From: Contact Centre (CRM) <contact@ribblevalley.gov.uk>
Sent: 16 March 2022 16:20
To: Planning
Subject: Planning Application Comments - 3/2022/0222

Planning Application Reference No.: 3/2022/0222

Address of Development: Land off Lincoln Way

PROPOSED SITE PLAN

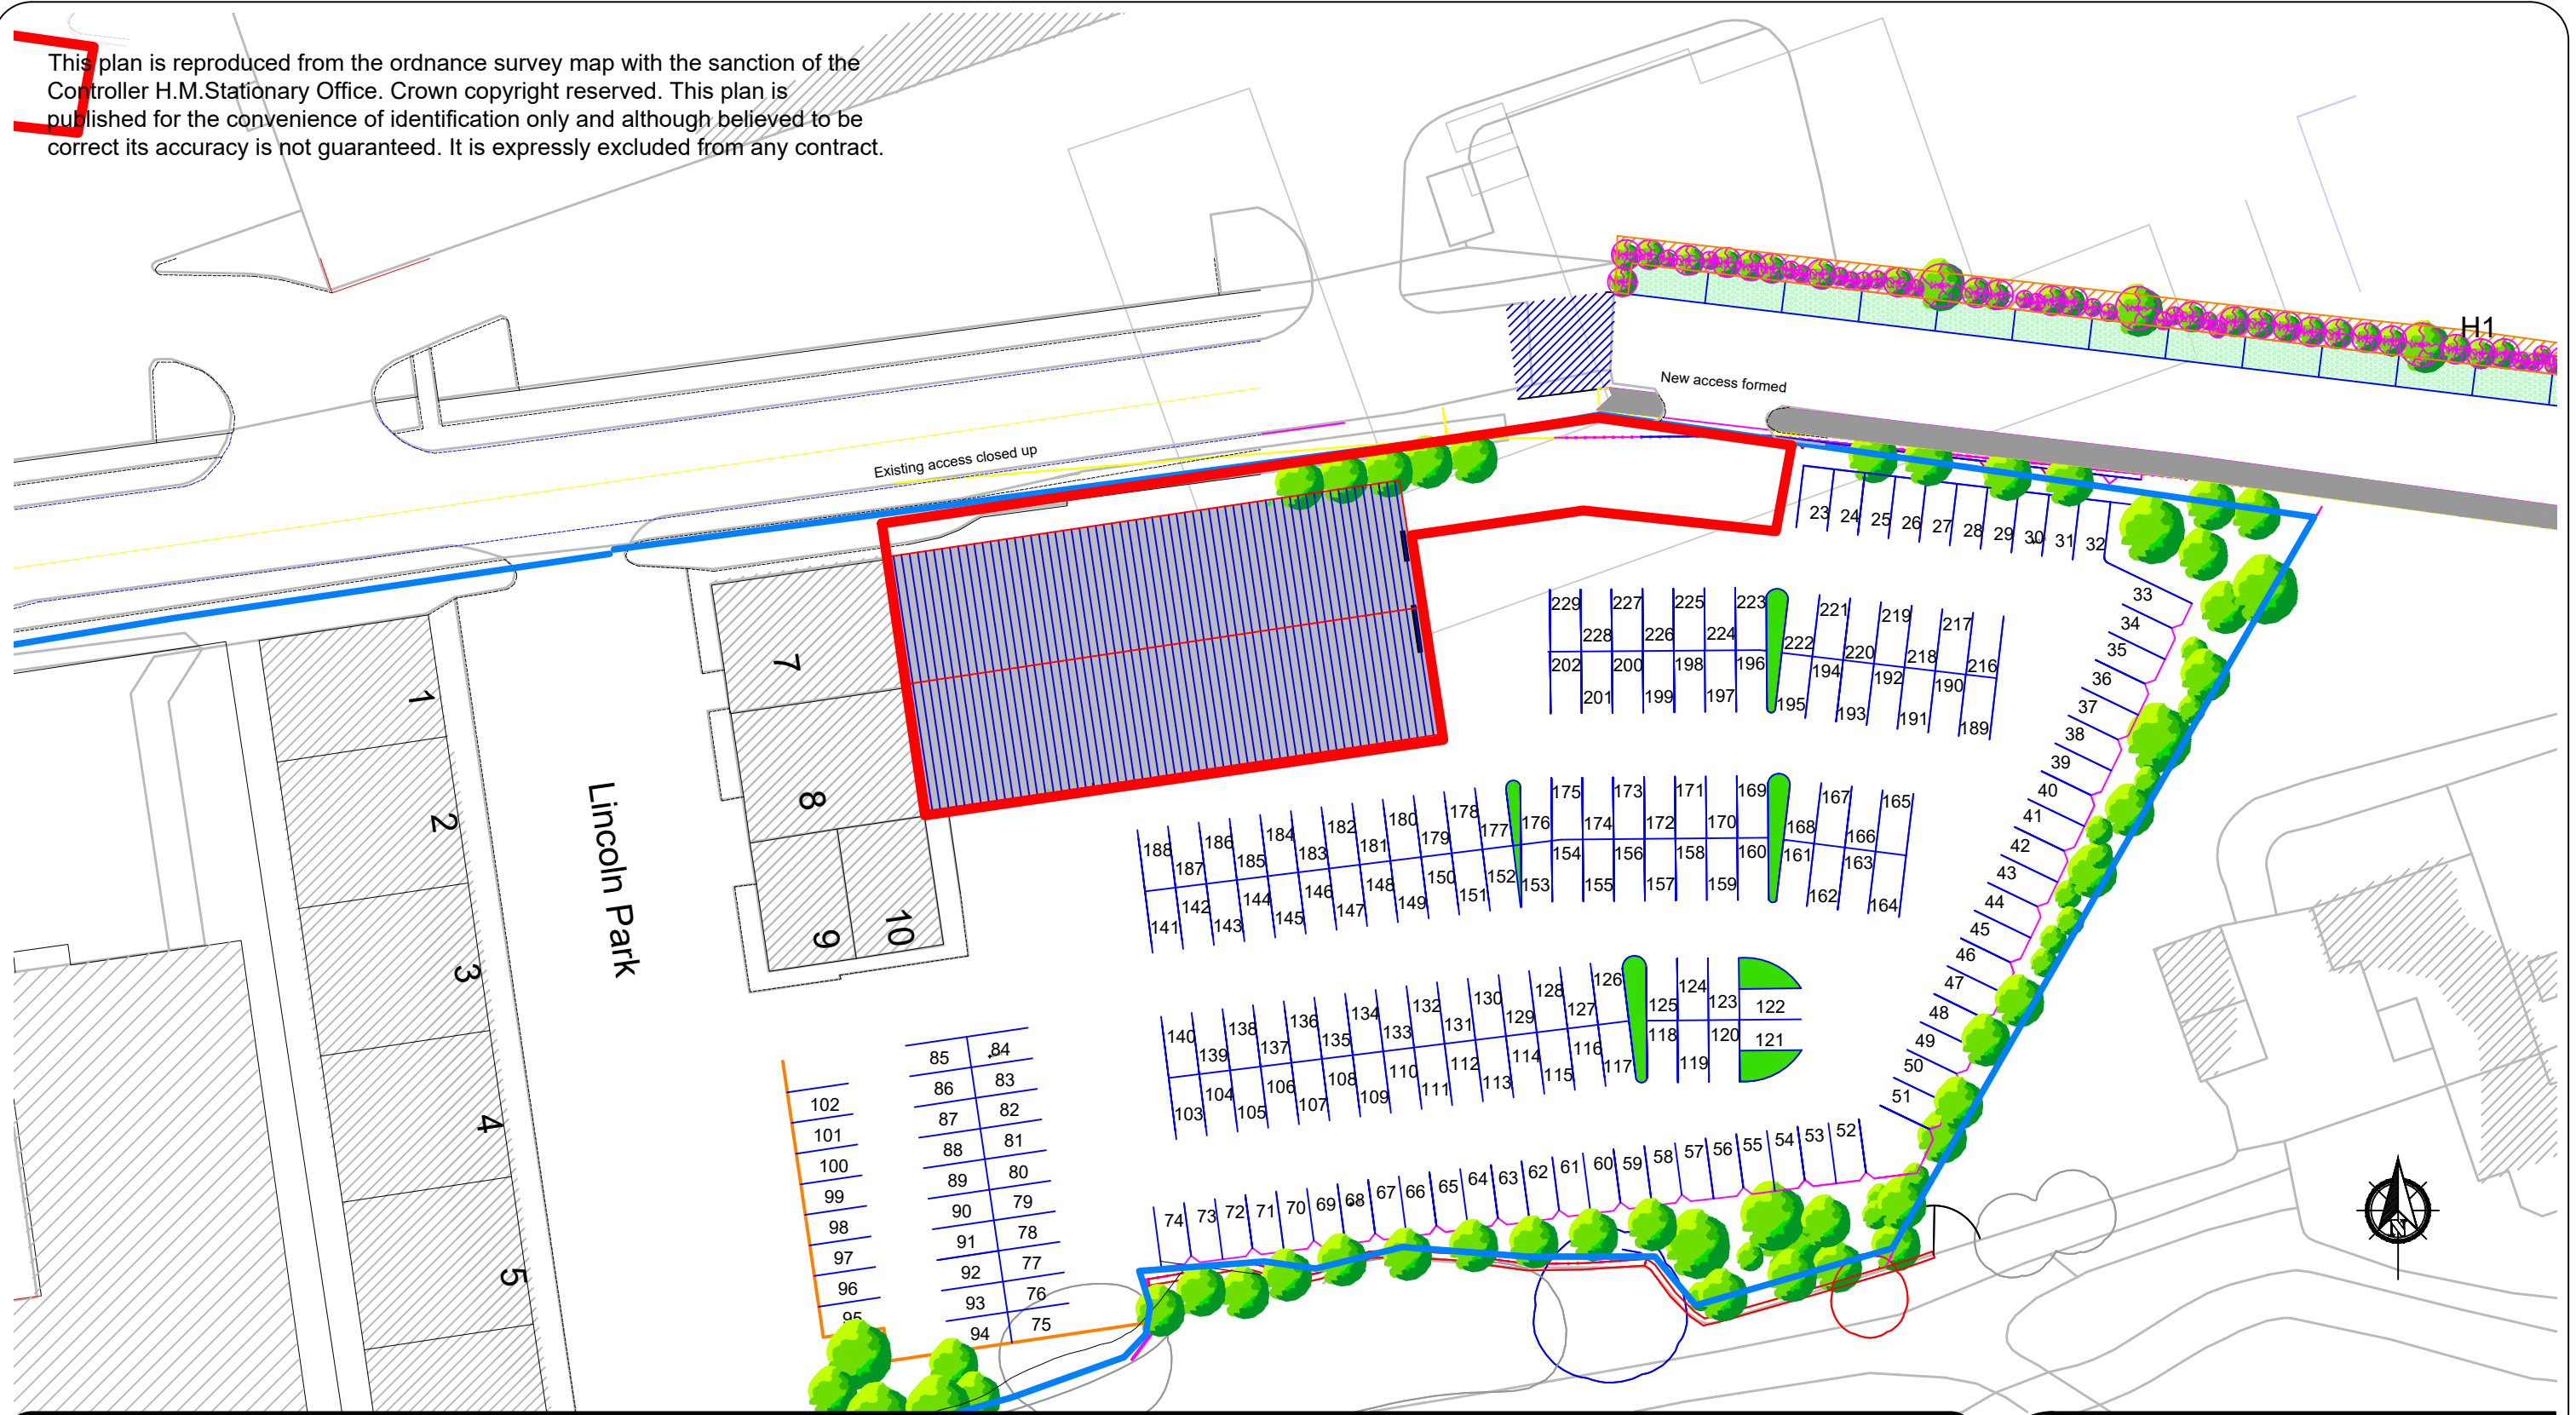
Comments: We have no objection to the proposed development provided the screening shown in green on the plan is implemented in its entirety.. ie Trees screening the development from residents in Upbrooks.
